Date: 15 September 2021
Our ref: 361084
Your ref: 3/2021/0661

Planning consultation: Marl Hill Section. From land northwest of New Laithe Farm off the B6478 Slaidburn Road; and land north of Cross Lane, near Sandy Ford Brook, off the B6478 Slaidburn Road; with highway mitigation works at various locations from Pimlico Link Road, Clitheroe to Slaidburn Road, north of Waddington, via Chatburn Road, Ribble Lane and Grindleton Road; a haul route from land south of West Bradford Bridge to West Bradford Road, west of Healings Farm, West Bradford; a vehicle marshalling facility on land at the Ribblesdale Cement Works, West Bradford Road, Clitheroe and a park and ride facility at the existing Ribblesdale Cement Works car park west of West Bradford Road. Proposed works for and use of replacement section of aqueduct, including earthworks and ancillary infrastructure including: new valve house buildings with infenced compounds with permanent vehicular access provision. With the installation of tunnel shafts; open cut connection areas at either end of the replacement section within temporary construction compounds, to include site accesses, storage areas, plant and machinery, and drainage inf

Figure 4: Braddup Compound indicative site layout 1

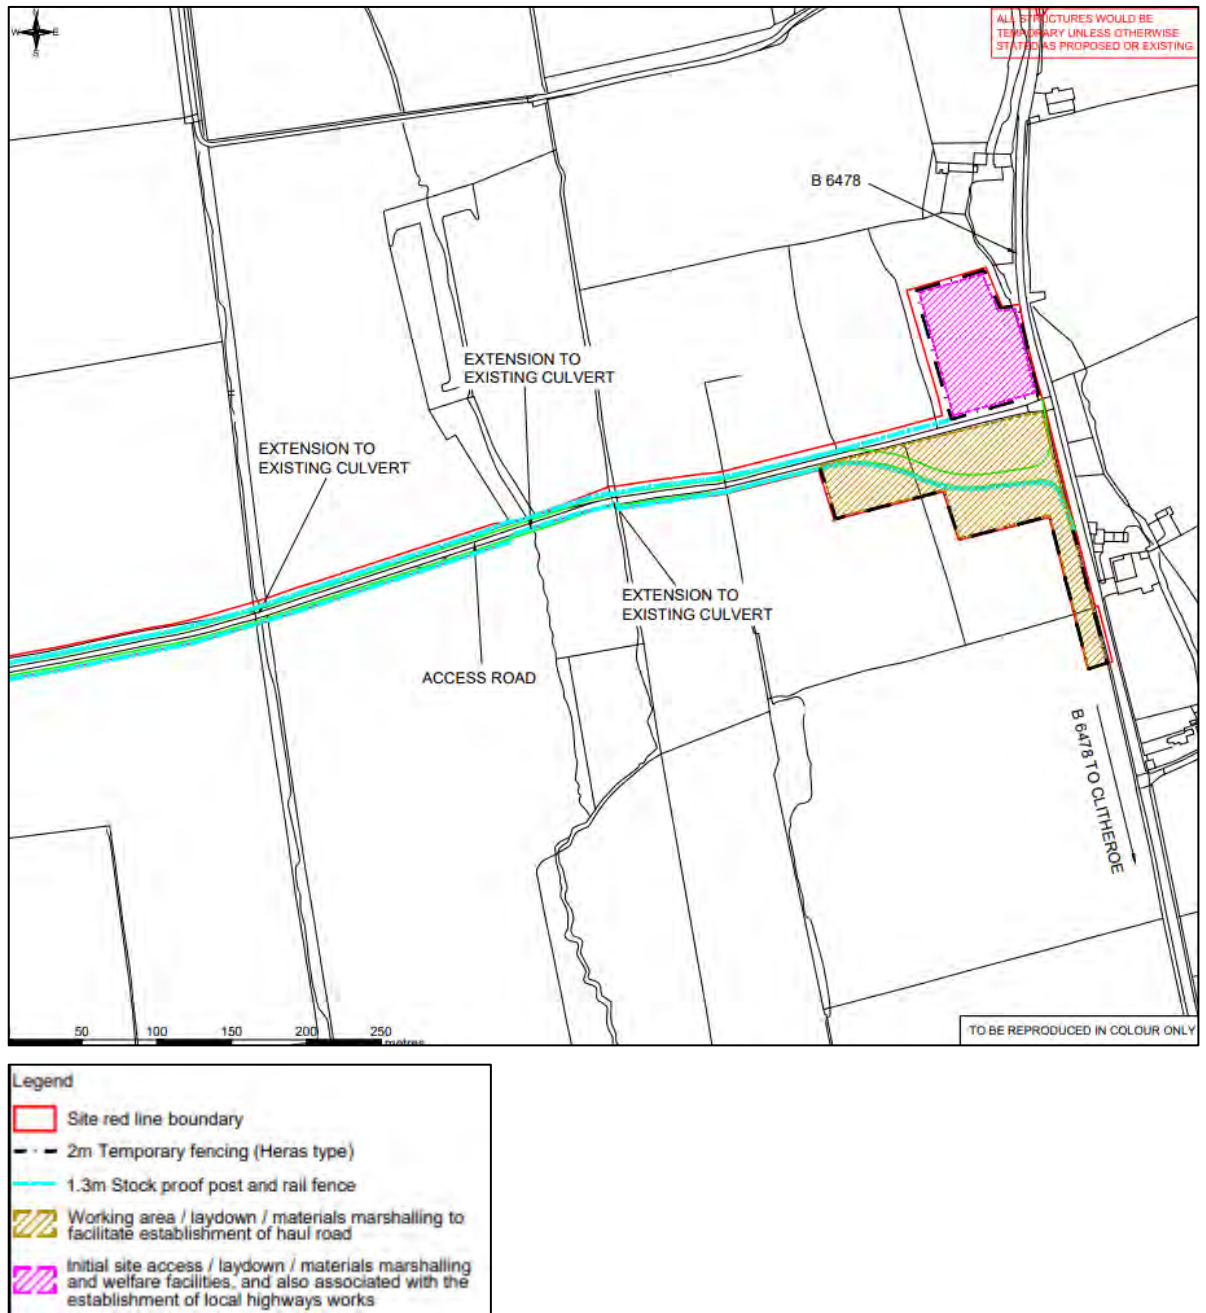
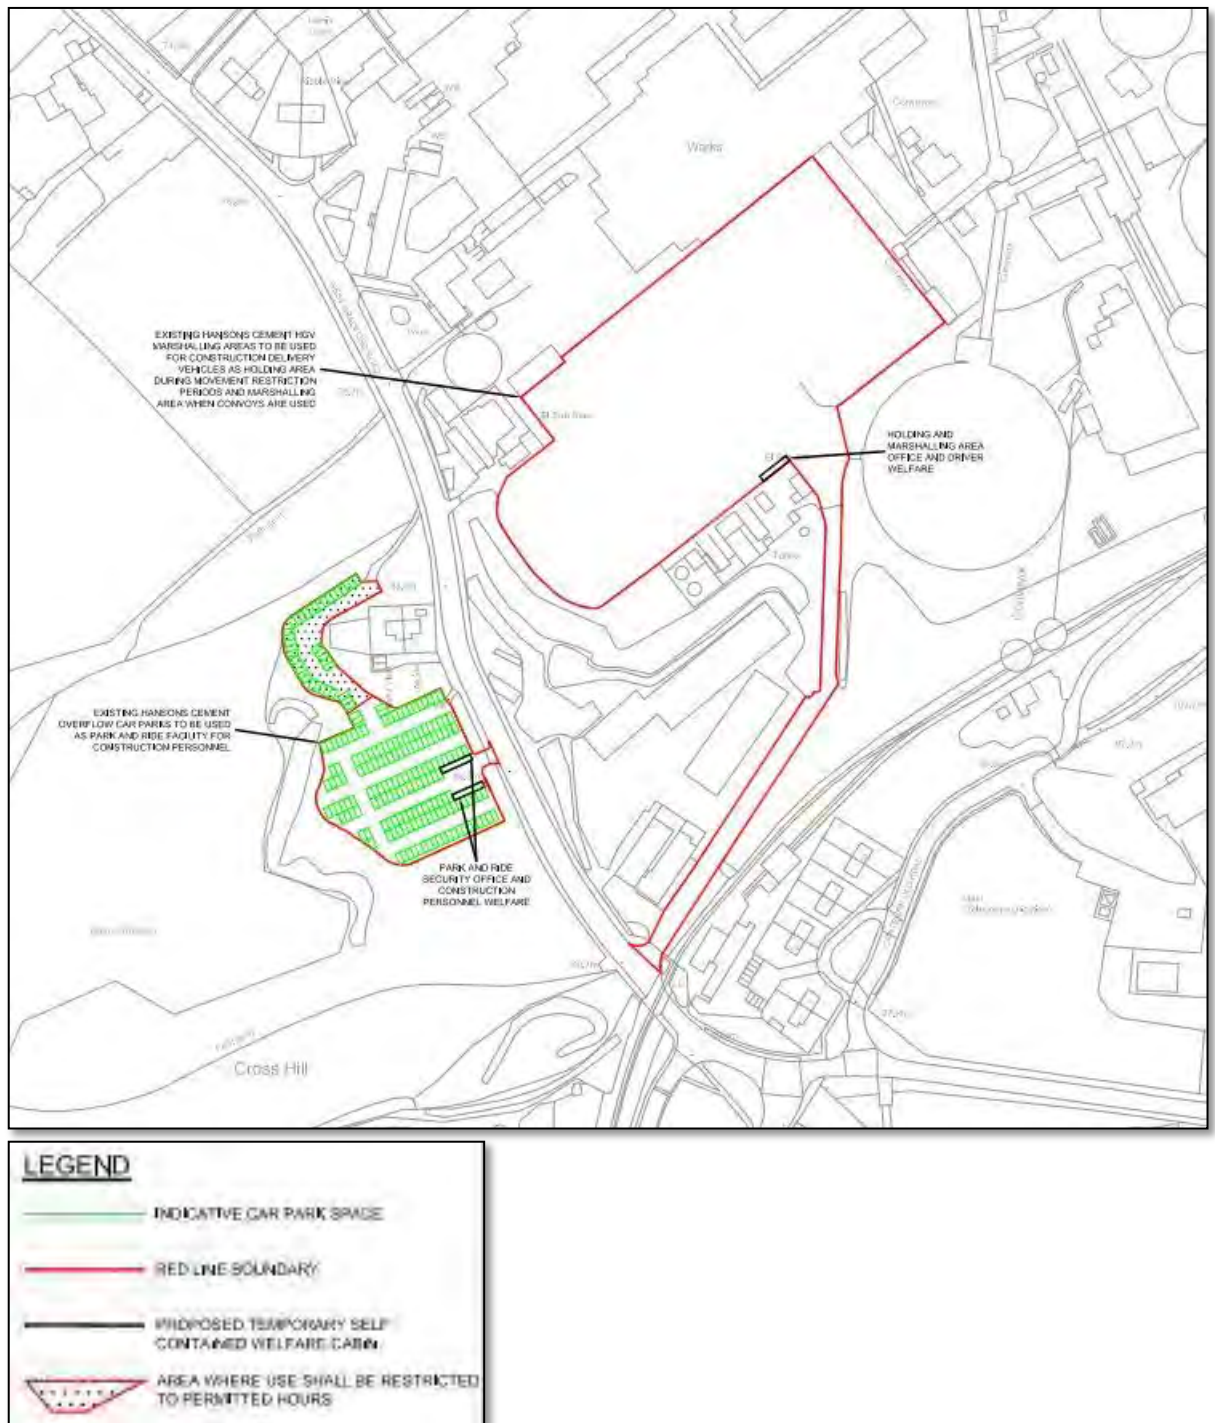
The submitted LVIA (ES Volume 2 Chapter 6) states that enabling, construction and commissioning works for the Braddup and Bonstone compounds will '..become the dominant feature in the view and would result in a substantial change to the character of the view. These high sensitivity visual receptors would therefore experience a major magnitude of effect, resulting in a major adverse significance of effect.'

We agree with this assessment. However, what is lacking is a clear explanation of why the compounds have to be located as proposed. If there is an overriding reason, presented against NPPF para 177b, for them being within the AONB then a careful search for sites which can best accommodate them should follow. That means searching for sites with the least sensitivity possible, including any existing screening and other mitigation that topography and/or vegetation can provide, together with any potential to enhance that mitigation. The ES chapters are not clear on what, if any, criteria relevant to national planning policy and the statutory purpose of the AONB were used to identify where the compounds and other key components of scheme should be located. Were other sites considered and assessed?

We note that no mitigation is proposed for any of the compounds as they are considered to be 'temporary'. We understand that the compounds will be removed and land reinstated once works are complete. In that sense they are 'temporary'. However, the works would be undertaken for a >10 year period which is a long-term presence within the AONB. Mitigation measures should therefore be considered, encompassing both the careful selection of sites and further screening and operational measures. The latter can include lighting and noise reduction strategies.
